Please upload the email below which is the revised consultation response from ADC Environmental Health to **LU/90/20/DOC** – Parcels A2 and B6, Hampton Park, Littlehampton.

Environmental Health:

Drawing No. 19163/400 S278 General Arrangement Plan / Vehicular Access

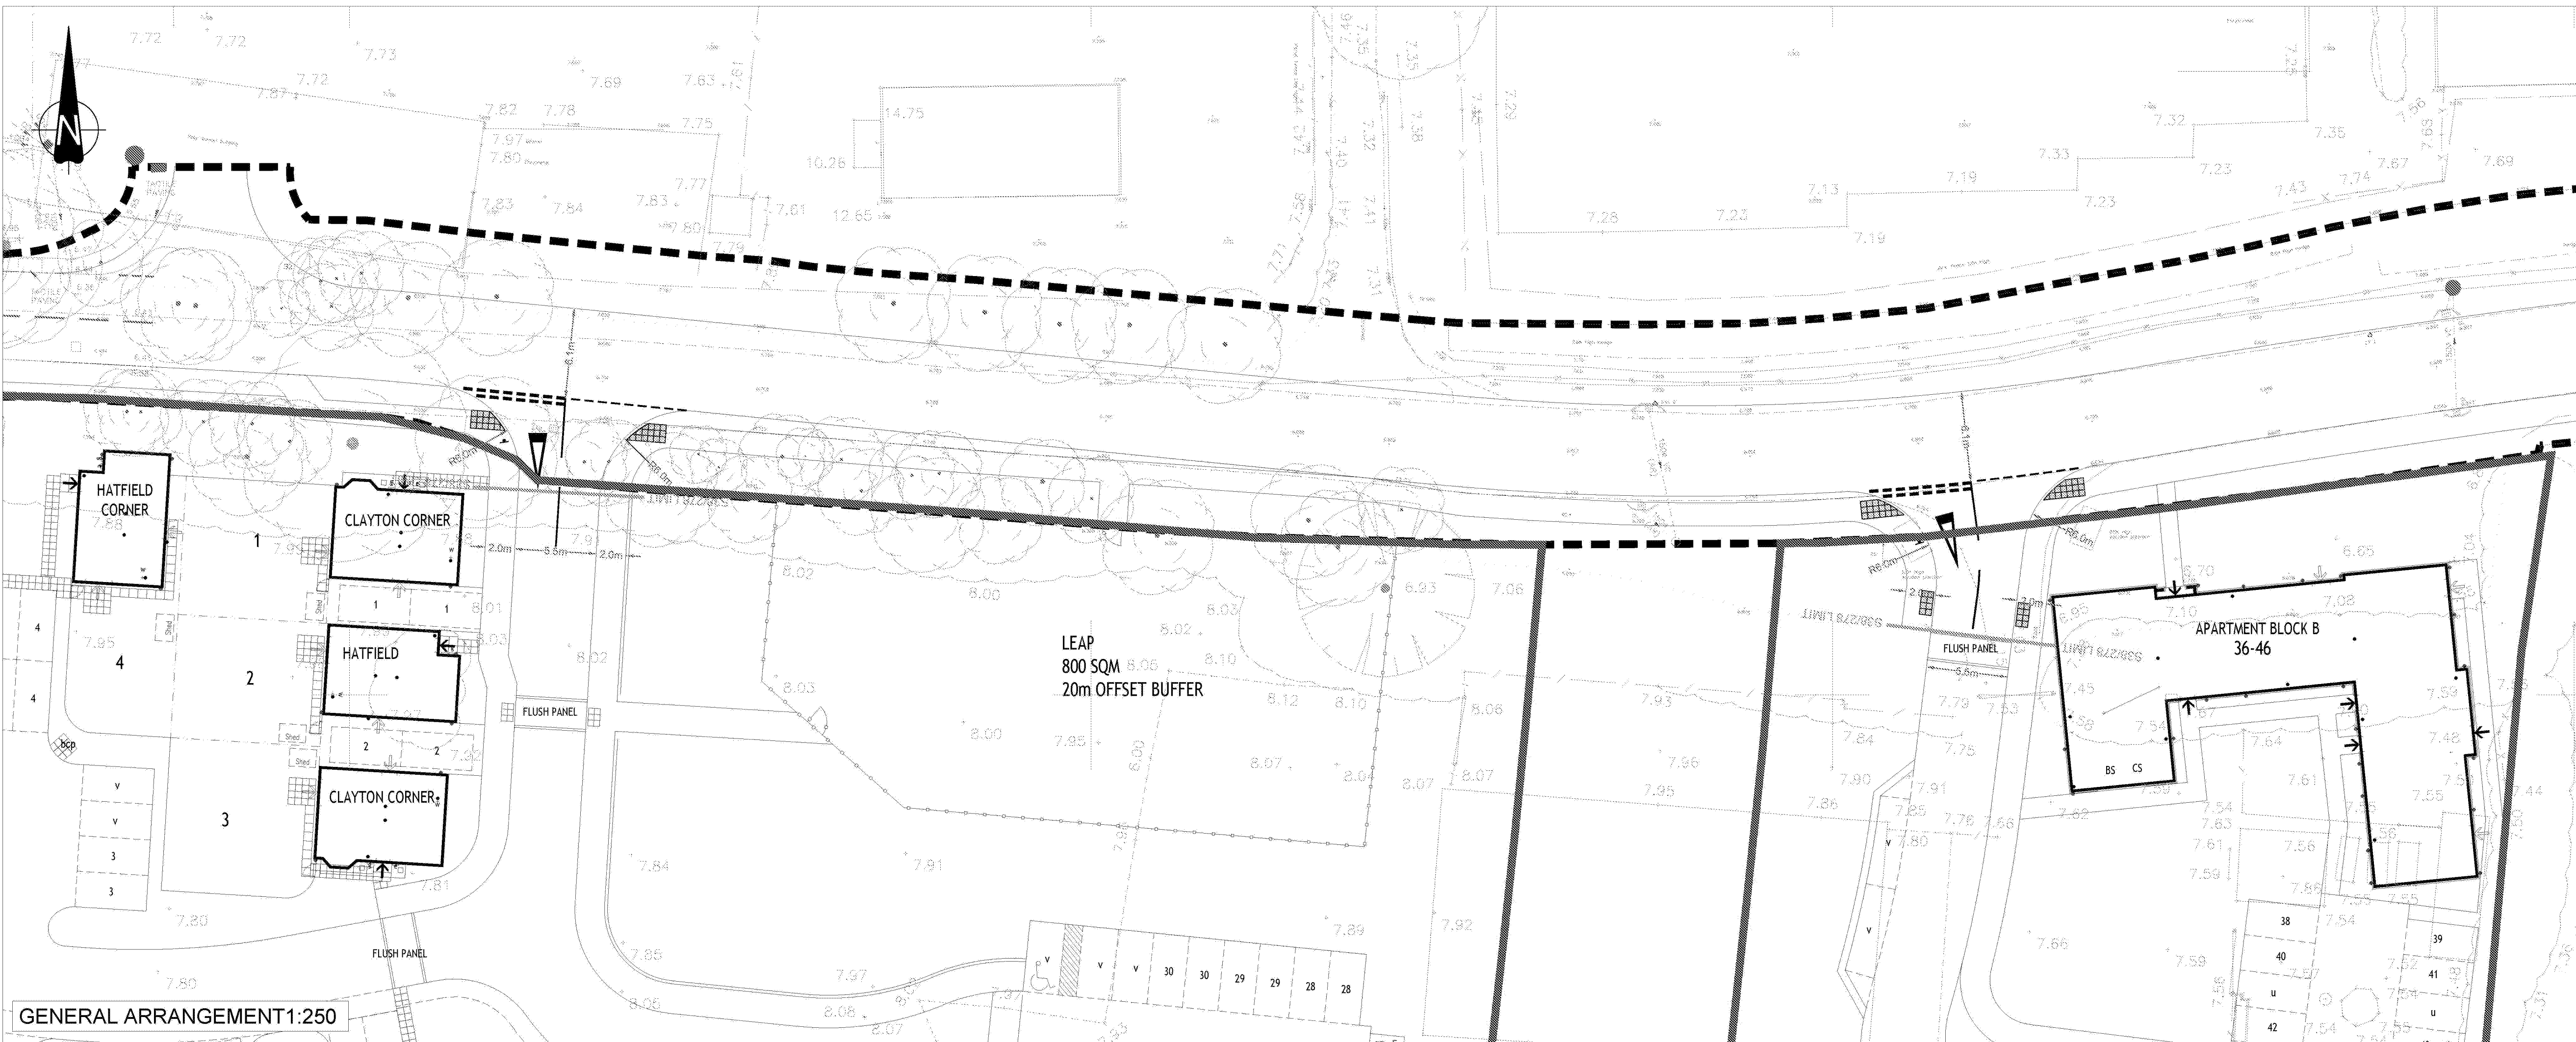
Condition 23 - Construction Compound. I note that a buffer zone will be provided to Parcel B6, which is defined in Appendix C of the CEMP relating to the southern section of the Lyminster By-Pass. This is in order to protect the amenity of sensitive receptors already built to the east of this site.

Agree discharge of Conditions 22 and 23
